34 - 36 Saunders St, Portland ME

Willett Duplex  
Project Name/Description

RE: Saunders Street Subdivision  
ID #2003-0022, CBL #130-F-021

**TO:** Kandi Talbot – Planner  
**FROM:** Jim Seymour – Development Review Coordinator, Sebago Technics, Inc.  
**RE:** 34 Saunders Street – Two-Family Home  
**DATE:** February 28, 2003

RECORD OWNER:	DRAWN BY: JDM	PLAN DATE: 11/20/02
	CHECKED BY: TFB/DNL	SURVEY DATE: Oct. 2001
	INSTR: Topcon GTS-3B	SCALE: 1" = 80'
FIELD BOOK: FS 518 & Topcon PFC	JOB No: 200176	SHEET No: 1 of 1

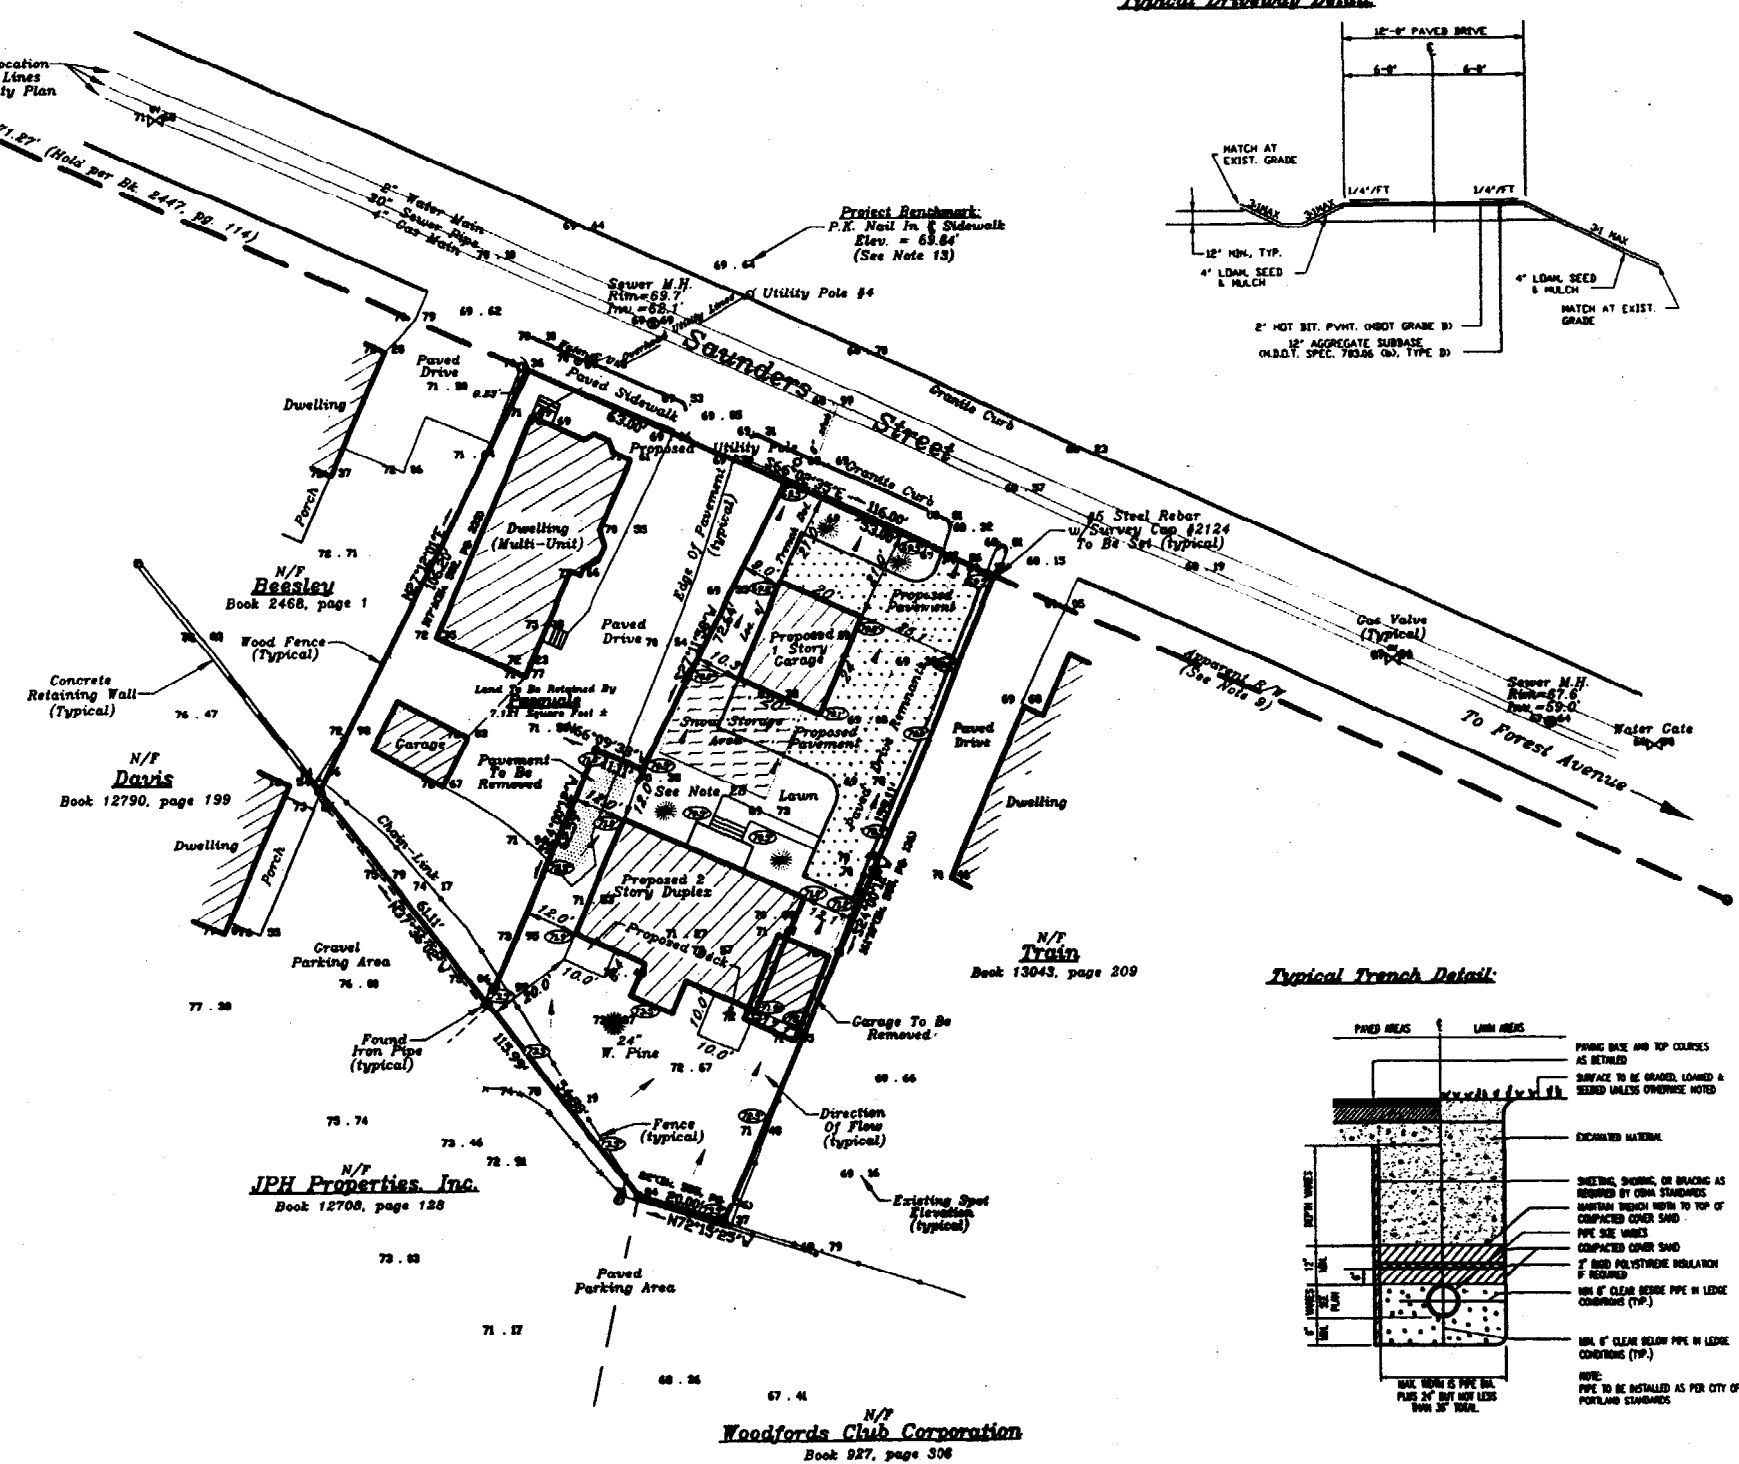
1. The plans need to specify proposed utility service connections, including natural gas, water and sanitary sewer.
2. The plans must also specify the anticipated utility trench excavations in Saunders Street.
3. The applicant needs to submit utility capacity letters as part of their applications, including a sanitary sewer capacity from Public Works Engineering.
4. The applicant is advised to contact Carol Merritt at Public Works to confirm the required permits and associated permit fees.

13. Is the applicant proposing to save the existing shrubs along the front at the sidewalk and between the proposed property and Train parcel abutting the easterly boundary of the project? Is so, a note should be added to protect these existing plantings as they provide an effective buffer.

14. Is any landscaping being provided? A total of four (4) trees are required and must be existing trees to be saved or meet City specifications for new trees.

15. As a result of the subdivision of the property, do both parcels have adequate area for snow storage? The snow storage areas should be designated on the plan for each lot? The concern is with how snowmelt in areas apparently available for snow storage, will effect neighboring properties. A note may be needed stating that excessive amounts of snow (banks or piles over 4 feet in average height) will be removed by contractor.

16. Will blasting of ledge be required to install the building foundations or utility trenches?
17. Need to provide typical details for the following: driveway pavement buildup section, sidewalk section, utility trench, and granite curb. A detail or note should be provided on the plan describing the proposed ground treatment.

18. Appropriate BMP details shall be included on the detail plan sheet.
19. The applicant must submit right, title and interest.
20. The applicant must submit evidence of financial and technical capability to undertake and complete the development including a letter from a responsible financial institution stating that it has reviewed the planned development and would seriously consider financing it when approved.

Care must be taken not to direct any additional stormwater runoff onto adjacent properties as a result of the proposed project being constructed. Careful placement of roof drain downspouts and site spot grades will need to be considered.

A. Provide inlet protection for catch basin in Saunders Street. Is there a catch basin located in Saunders Street in front of the project? (Note: Street was snow/ice covered during the time of the field visit.)

B. Appropriate BMPs will need to be shown installed on the plan.

C. Although the spot grades can be useful the plan will be more beneficial if contour lines can be provided in 1 foot or two foot intervals. Spot grades are useful if the ones shown represent finish grades in areas where drainage is of concern or elevation is critical in relation to the existing or proposed structure.

- A. Letters must be obtained from utilities stating that adequate capacity exists.
- B. Existing utility information, such as inverts for sewer manholes, pipes and stubs and approximate locations of sewer stub, water and gas mains should be shown on appropriate plan sheets, along with proposed building utility service run locations.
- C. Will all utility services be installed underground?
- D. Is the applicant proposing to provide electric service from utility pole #4 shown on the survey plan?

- A. According to Nadeau and Lodge Survey note number 13, the plan elevations are based on an assumed datum. Care should be taken, especially with the sewer service design, to determine the appropriate adjustment factor necessary to accurately compare project elevations to existing sewer infrastructure elevations.
